**SOILS AND GEOLOGY STUDY
RETREAT AT TIMBERRIDGE FILING NO. 4
PARCEL NO. 52220-00-023
EL PASO COUNTY, COLORADO**

Prepared for:
**TimberRidge Development Group, LLC
2138 Flying Horse Club Drive
Colorado Springs, CO 80921**

December 21, 2023
Revised June 17, 2024

**EXTENDED DETENTION BASIN DETAIL**

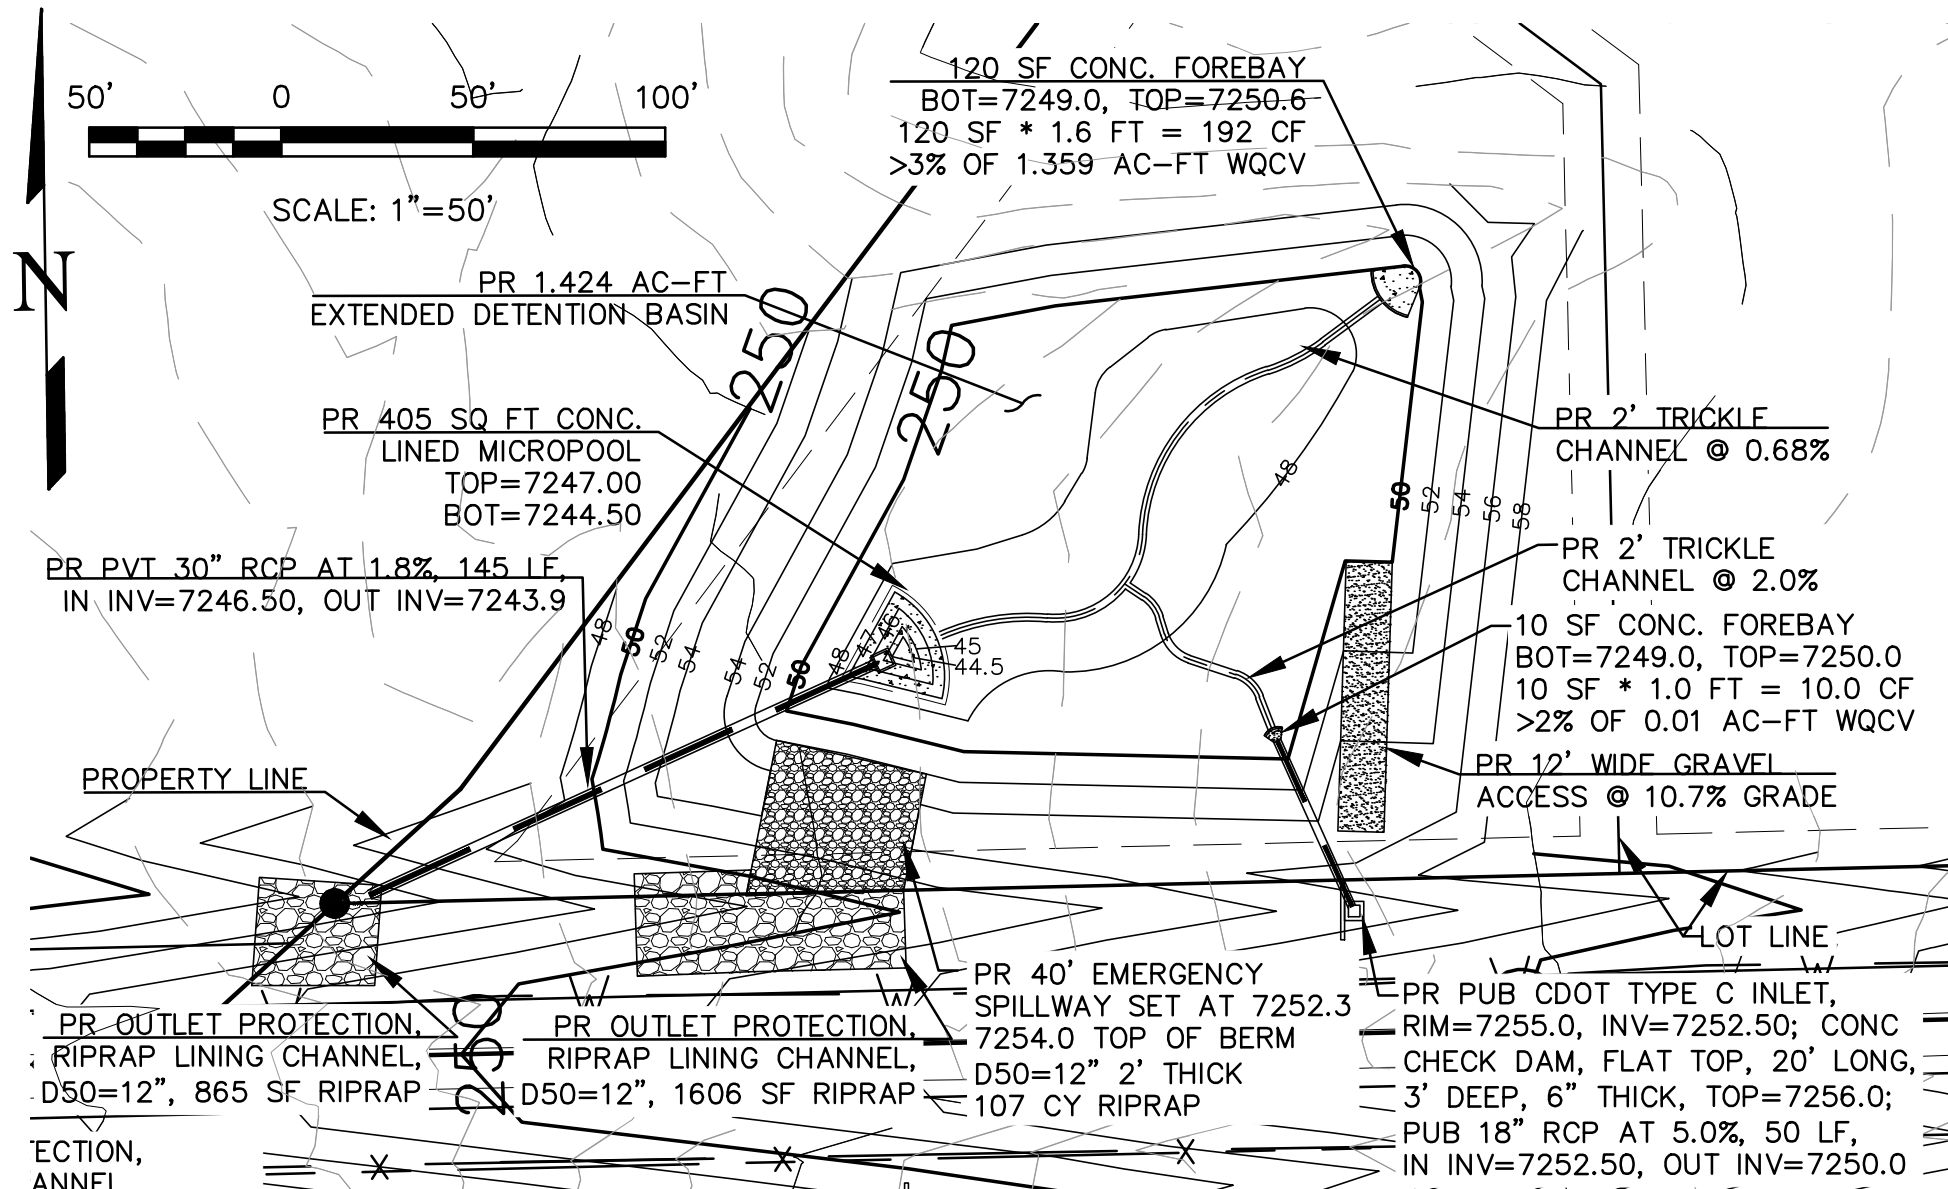
Unresolved. See comment from v2. Please elaborate, I'm not seeing how an inlet at approx. el. 7260 is going to mitigate potential groundwater issues within the pond (el. 7250 - 7256).
